City of Albuquerque

Re: Snow Heights Shopping Center Grading and Drainage Plan
Engineer's Stamp dated 5-20-00 & 6-6-00 (H20/D9)
Address: 2009 Eubank Blvd NE

Re: Snow Heights Shopping Center Grading and Drainage Plan
Engineer's Stamp dated 11-15-99 (H20/D9)

GRADING & DRAINAGE PLAN

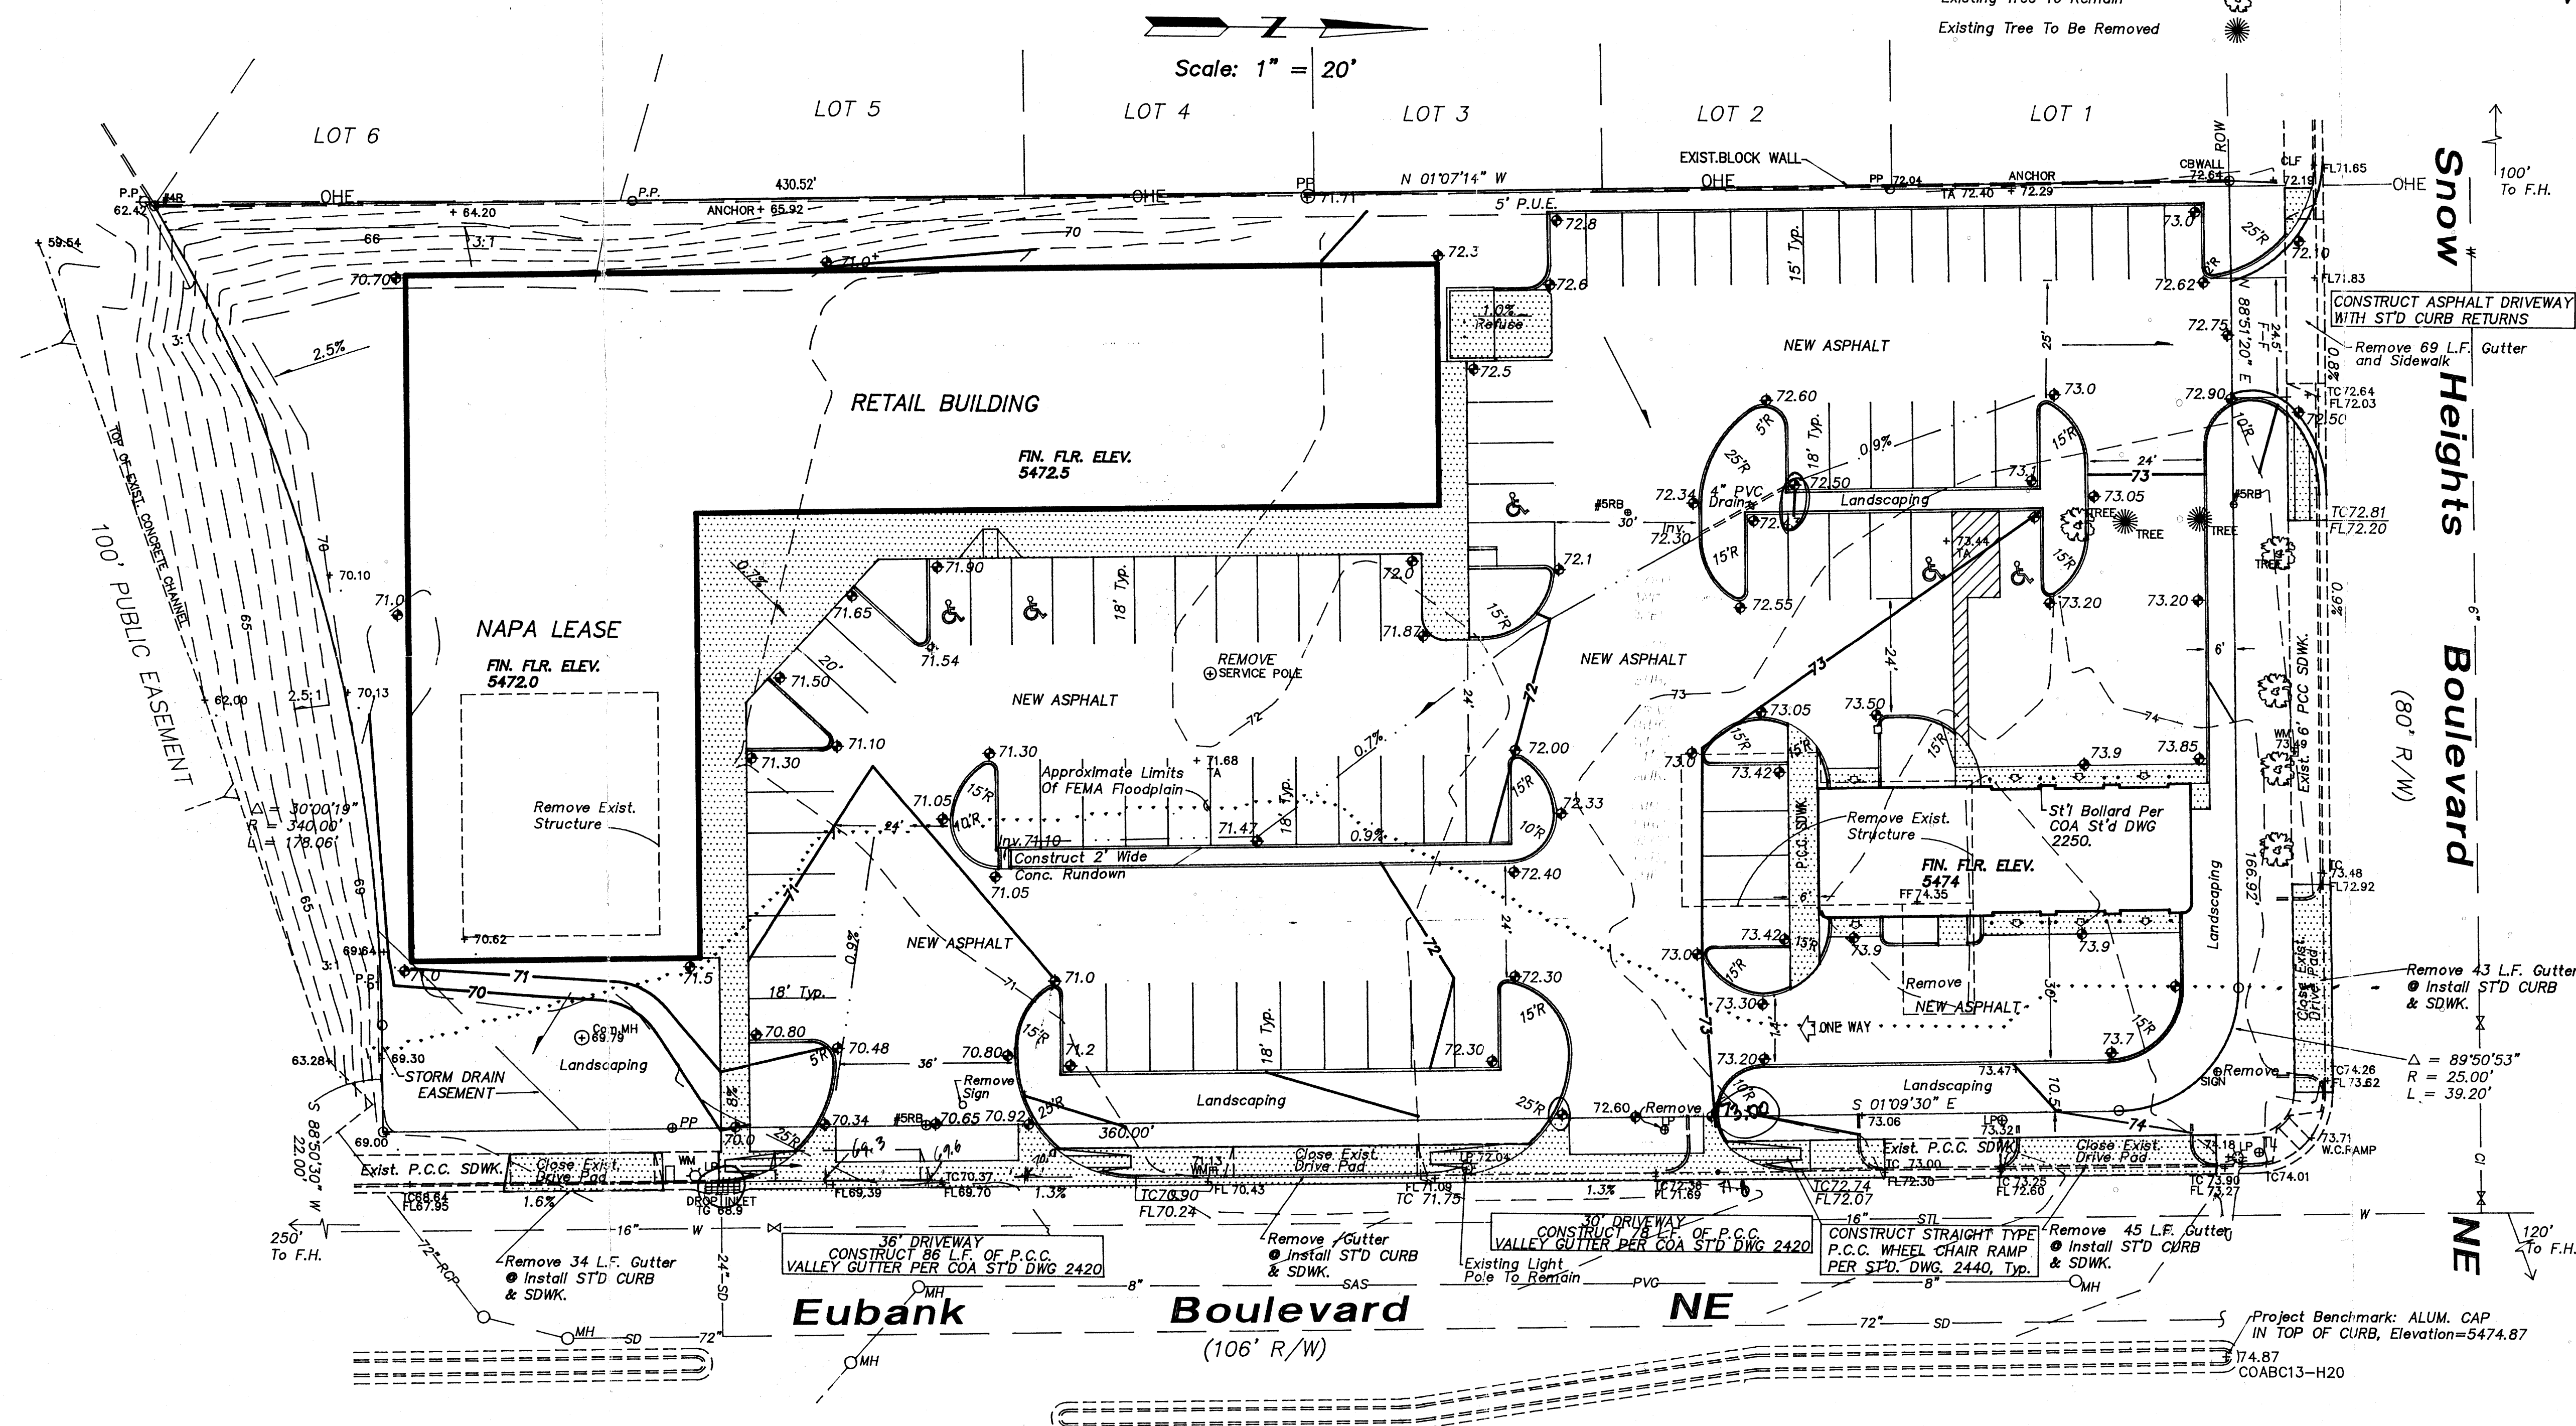
1. As with any drainage submittal, a calculation of existing site runoff and proposed site runoff (per your note 4) is required. Please show all existing land treatments; you do show existing buildings but I also need existing asphalt parking, landscaping, etc. You are correct that there is capacity downstream, however, discuss where your runoff goes and what infrastructure is in place.

2. Roof runoff locations must be shown on the plan. If roof runoff is allowed to drain to the back (north and west sides) of the building, a swale and slope protection must be provided to protect property owners downslope. It also appears that you are adding a little fill to the slope in the NE corner. It looks like this slope is already at 3:1 so any fill would increase this slope. Therefore include erosion control measures in your plan.

3. Transportation comments about driveway slopes will change your grading plan slightly. You will still need a 1-foot water block at the driveway. It also appears you are planning to modify the existing drop inlet by the south drivepad. Modify site plan to miss this inlet or explain what modifications will be done.

4. Per City ordinance, all building finish floor elevations must be 1' higher than the adjacent water surface elevation, which in this case is 1' above flowline. Your finish floor for the retail building is adequate but raise the auto lube building to 5475.0 to achieve this.
